**16-24 LORD STREET AND 21-27
ROSEVILLE AVENUE, ROSEVILLE –
RESIDENTIAL DEVELOPMENT**

BCA Assessment Report
Report 2024/2808 R2.1

Prepared for Hycorp
November 2025

**REV.** B  
**DRAWING NO.** SSDA-096

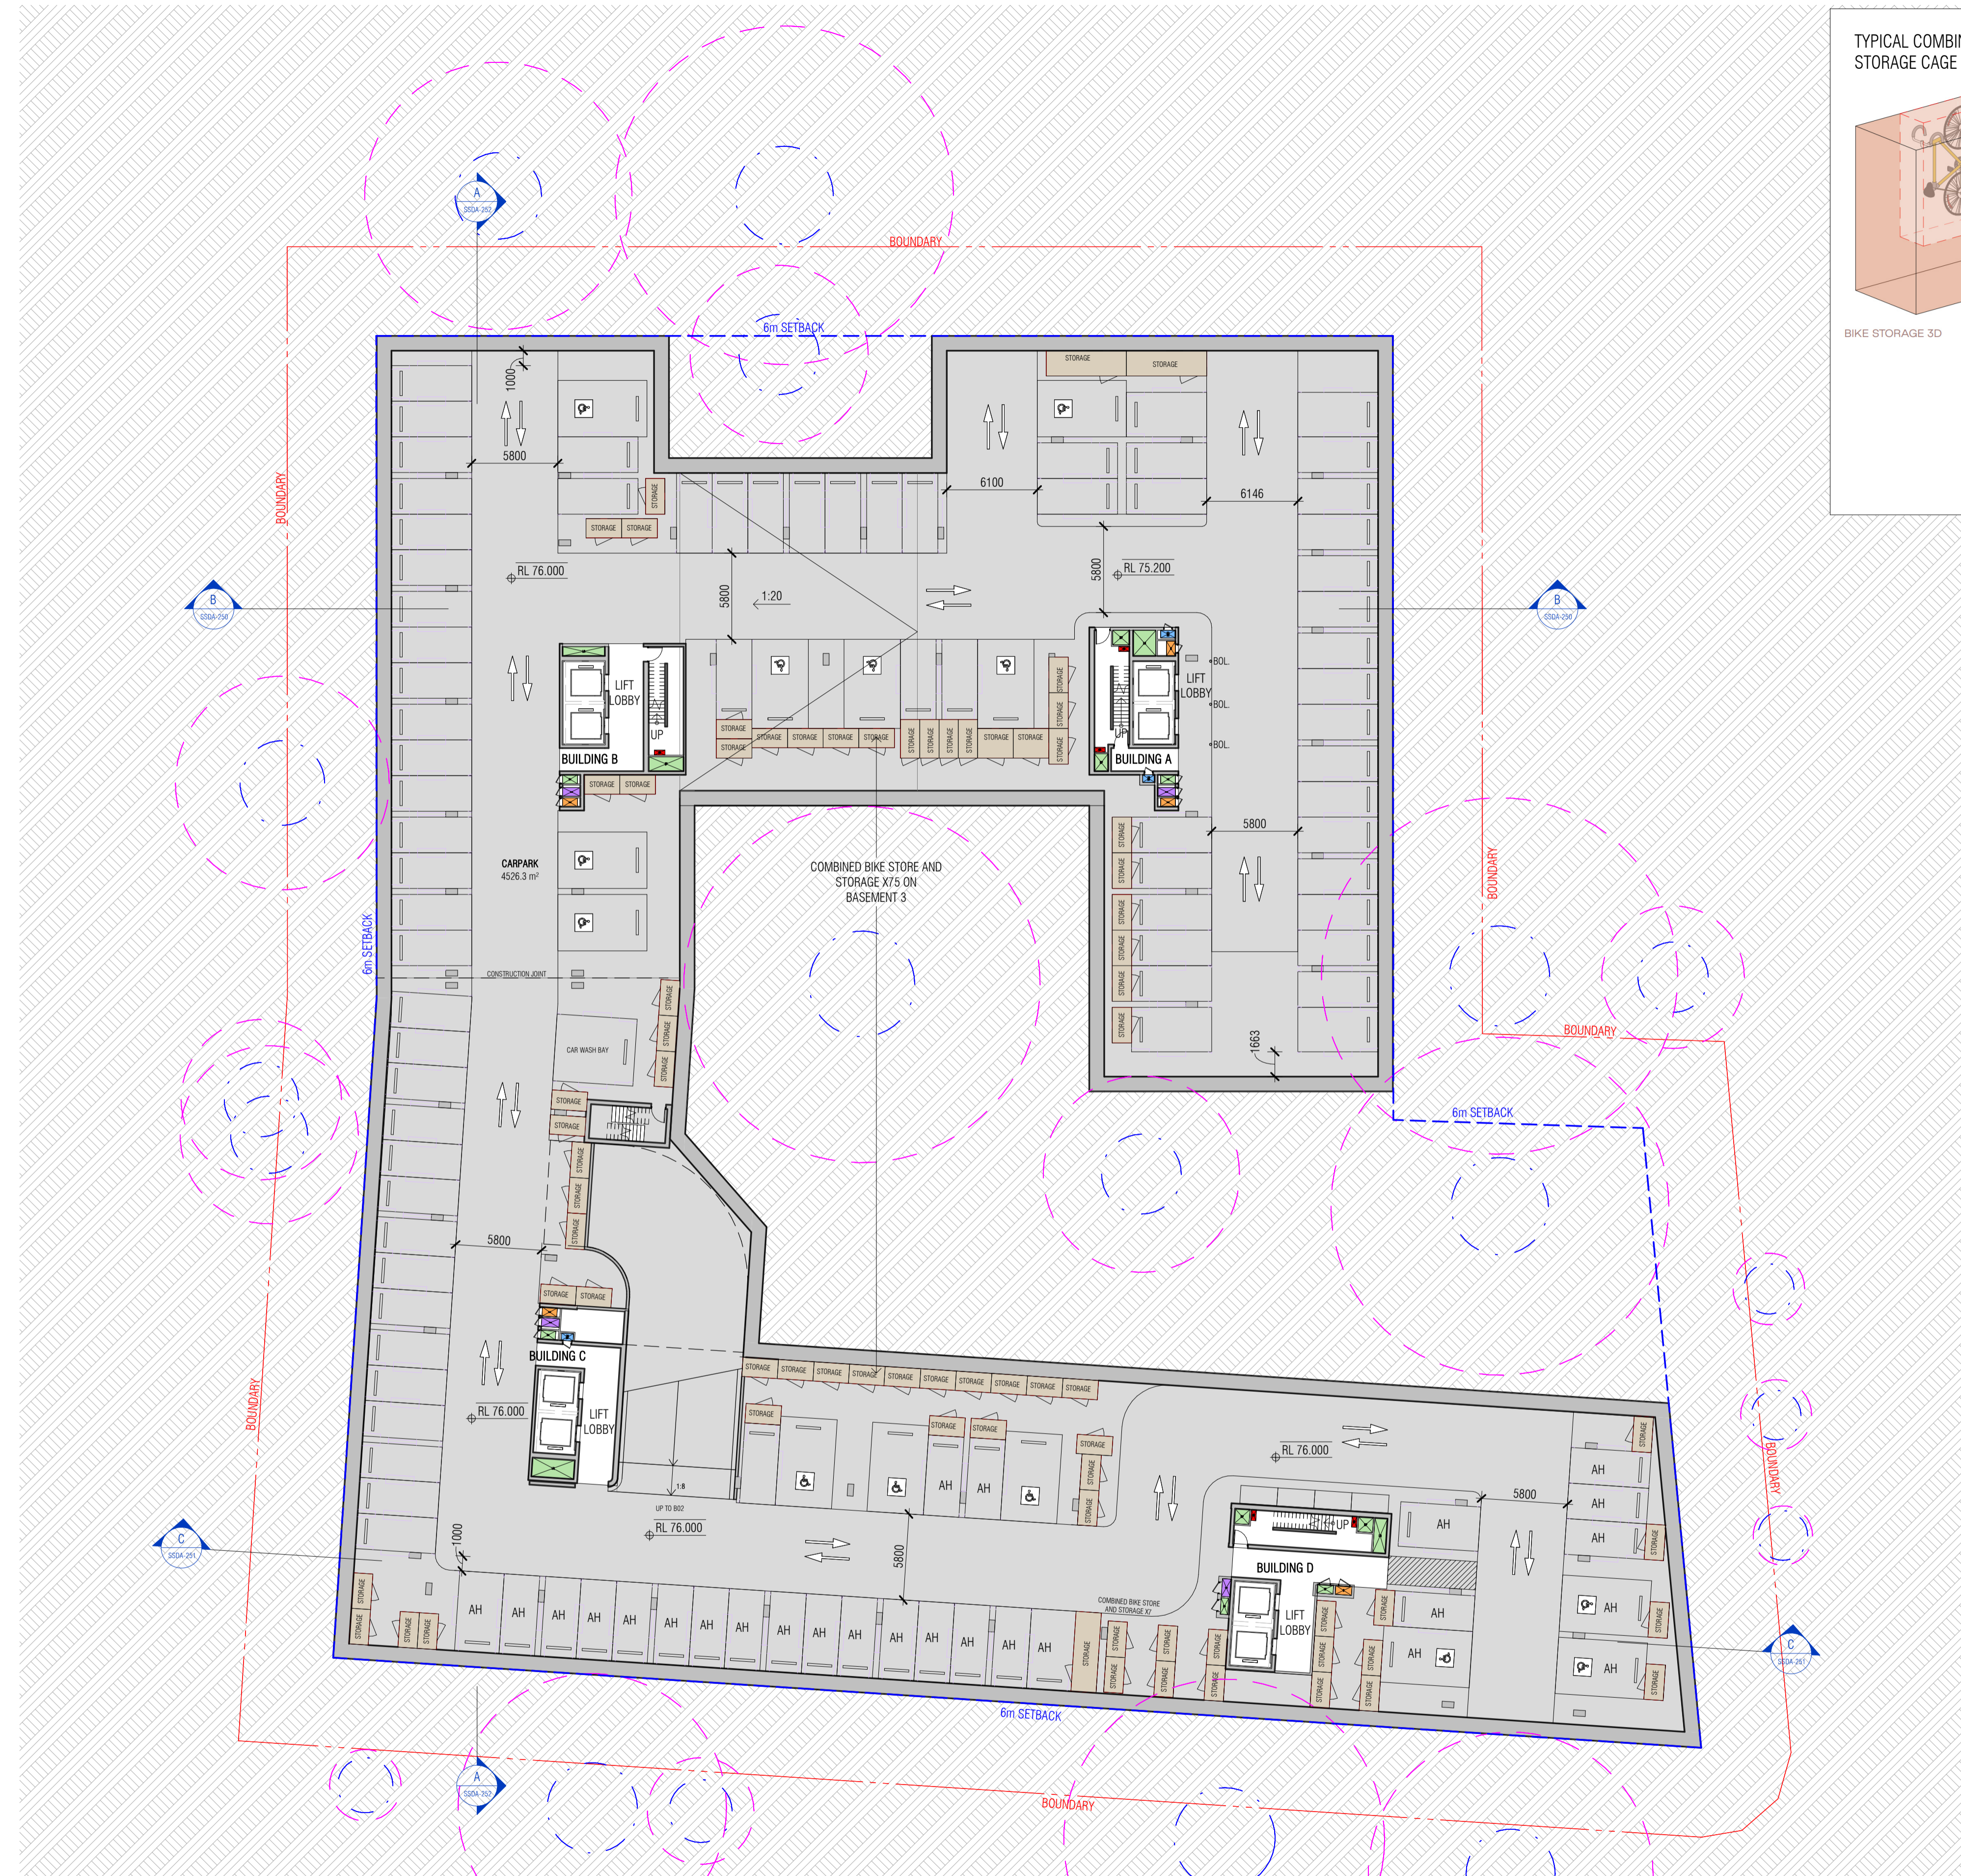
6. Fire extinguishers required within 10m of every residential SOU entry door. Compliance will need to be documented as part of detailed design.
7. Dead end Travel distance exceeds 30 m from the South East Corner of the basements under Building D. Dead end travel exceeding 30m from an area normally used by the occupants is unlikely to be supported by a Performance Solution and the exit arrangements will need to reduce the dead end travel to a distance that can be supported under a Performance Solution.

REV. B  
 DRAWING NO. SSDA-097

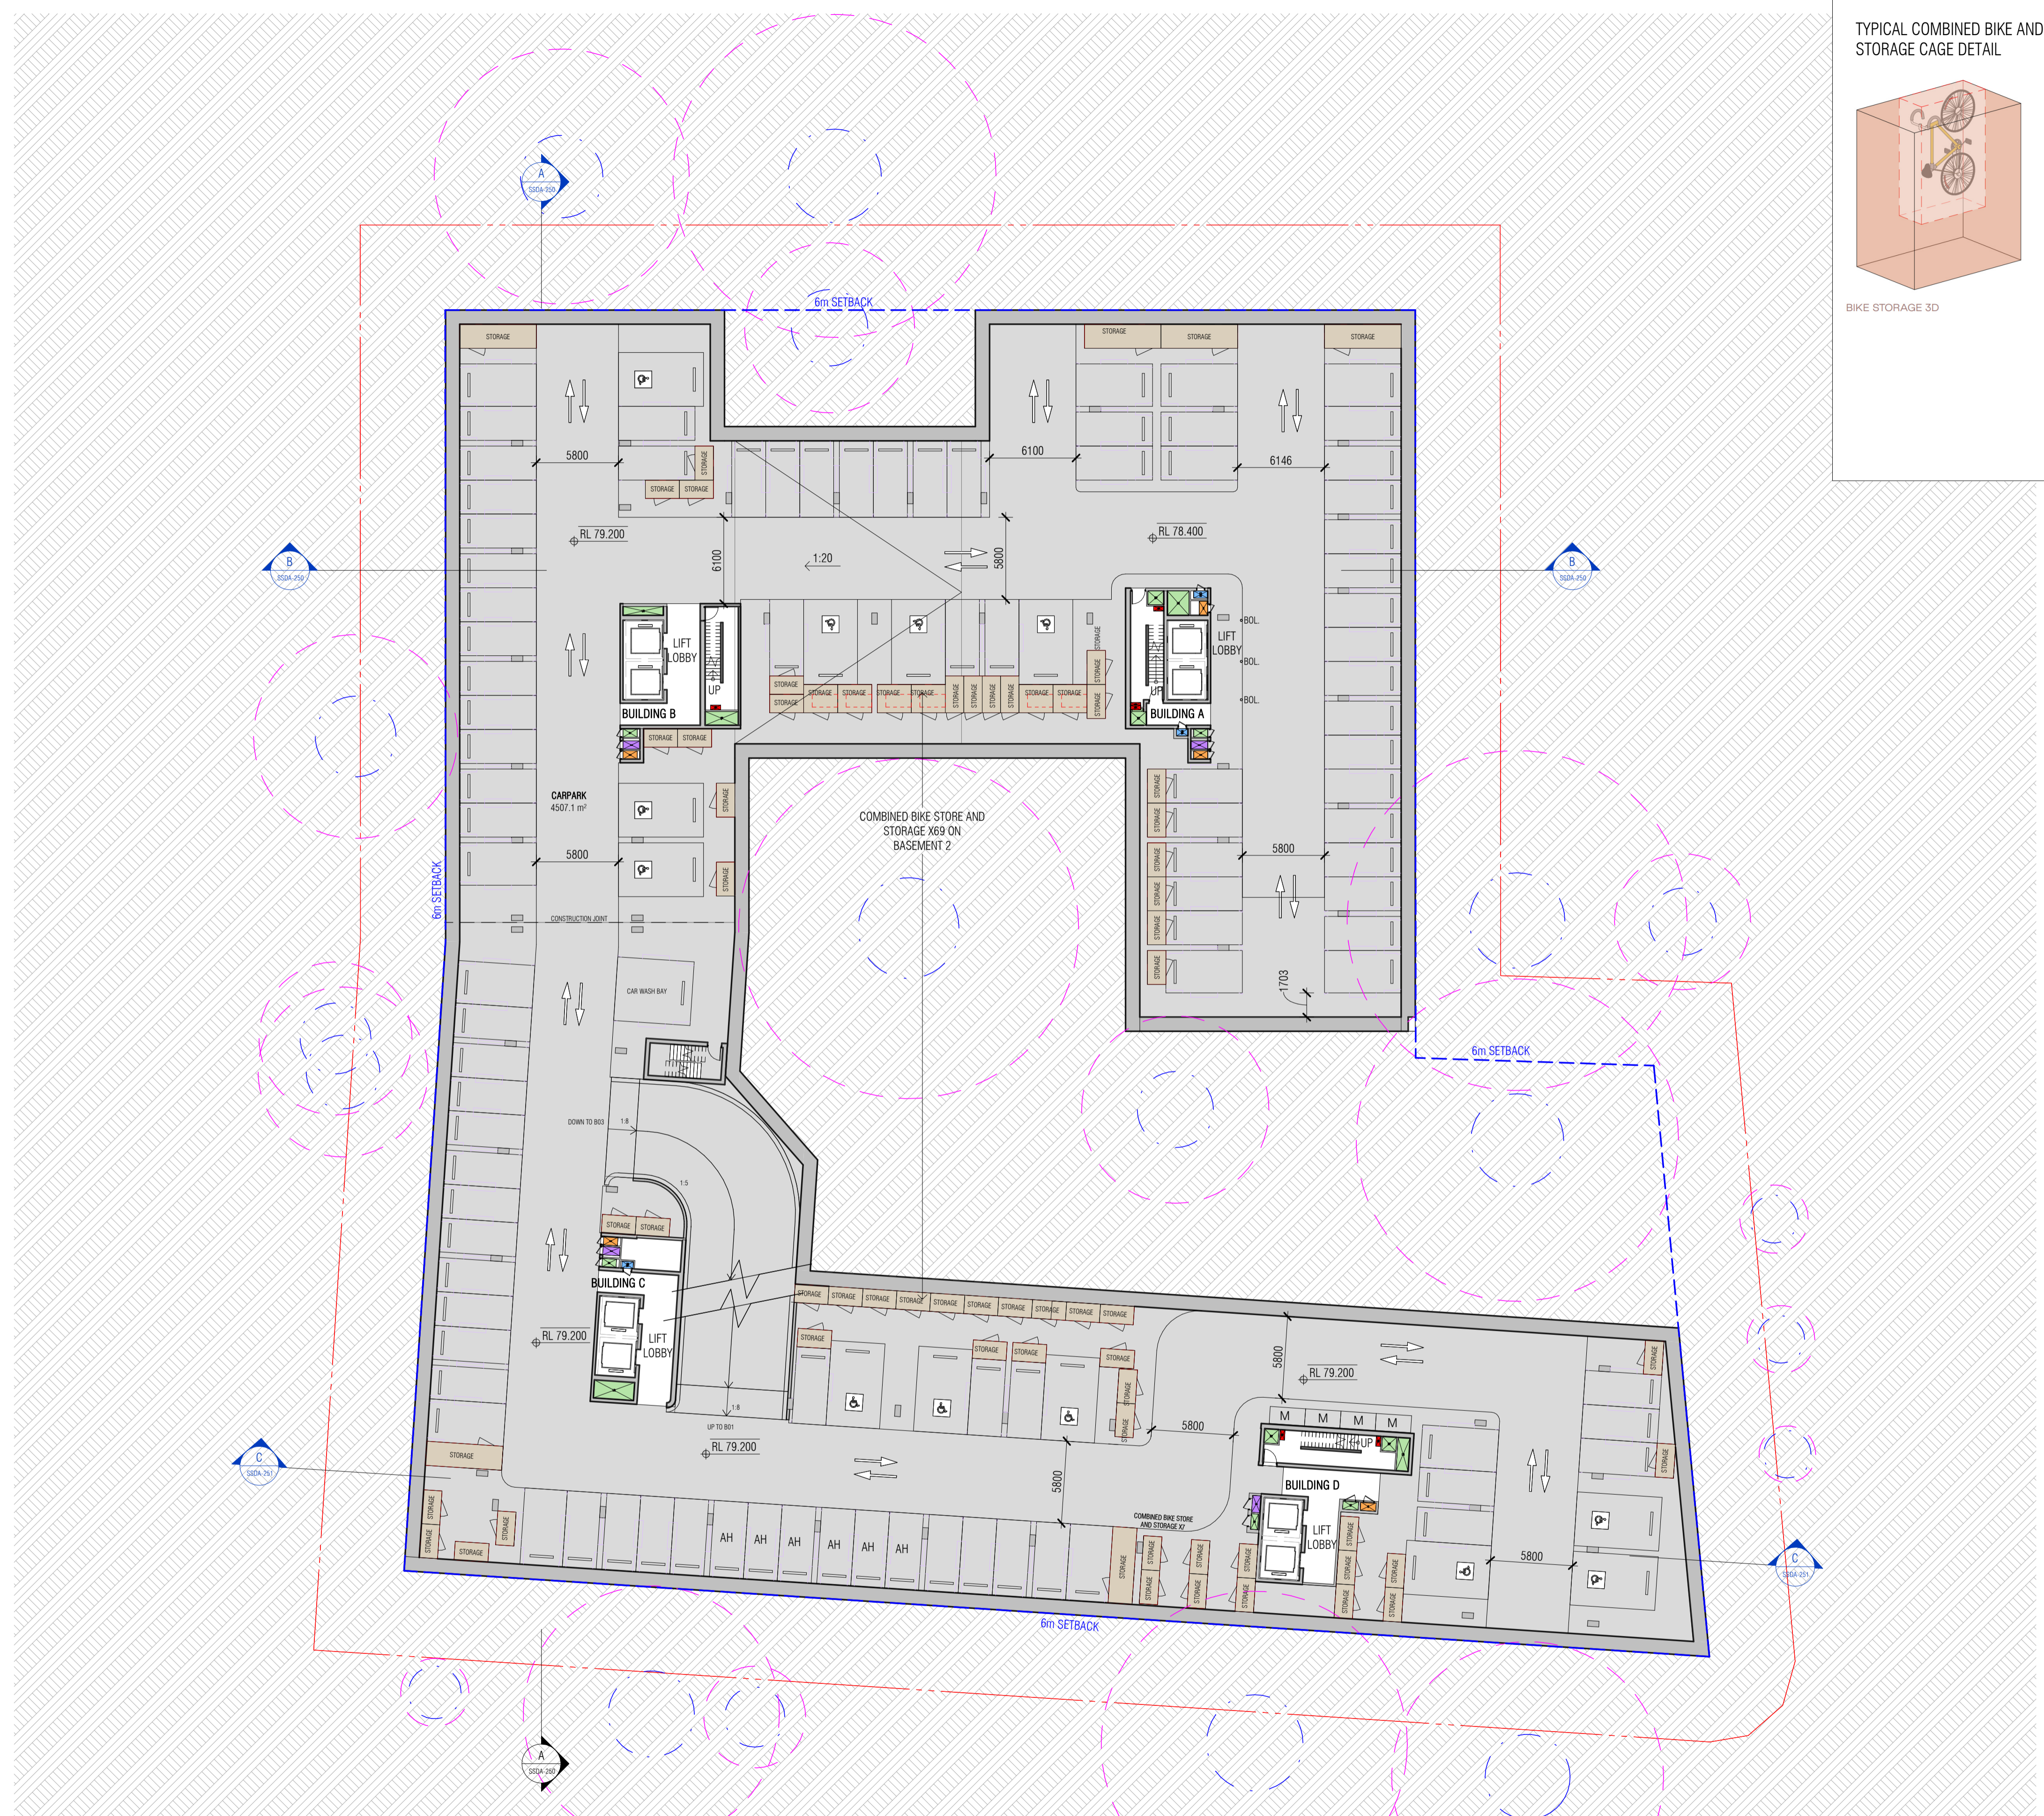
6.	Exit travel distances	D2D5	To permit a dead end travel distance of up to 35m to a point of choice from the 'Pool Void' on basement level 01 will require a performance solution.	D1P4 & E2P2
